City of Albuquerque Stormwater Construction Site Inspection Report

ESC File No.	C12E003C	Project Name:	Learning Experience		
NPDES Id. No.	NMR10032L	Location:	4580 Nunzio Ave. NW		
5/7/2021	Owner	Contractor			
Operator	Learning Lab Development PER LLC				
Contact name & title	Scooter Haynes		Dustin Feuell		
e-mail	scooter@scmpartners.com		dustinfuell@icloud.com		
Contact Phone #	505-898-6622				
COA Inspector	Thomas Evans		Start/End Time:	11:00 AM/11:30 AM	
Construction Phase:	Building construction				
Type of Inspection:	☒ Regular	☐ Storm Event	☐ Past Storm Event >0.25"	☐ 311/Complaint	☐ Follow Up
Weather at time of inspection?	clear		Temperature:	~ 77	
Estimated date of last storm 0.25" or greater	5/3/2021

TEMPORARY EROSION AND SEDIMENT CONTROL PLAN

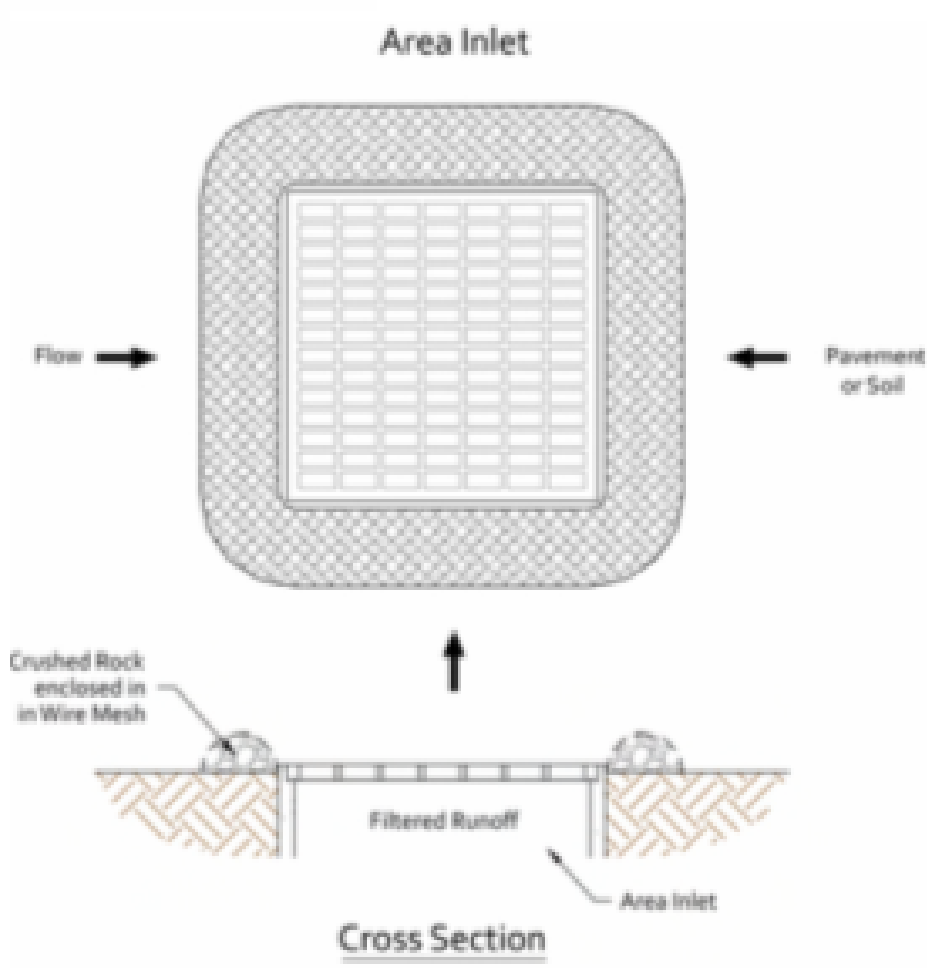
Item Number	Deficiency/ Corrective Action				
1	Sediment accumulation against the South silt fence. Remove sediment from the silt fence. Maintain sediment control BMPs.				
2	Sediment accumulation at the inlet. Remove sediment and re-position wattle to prevent sediment from entering the inlet.				
3					
4					
5

Notes: Spoke with superintendent. Cranes are coming in on Tuesday, and the dirt pile on the South side will be cleared from the fence. No vehicles are parking on site. They are using the adjacent lot to the South for staging.
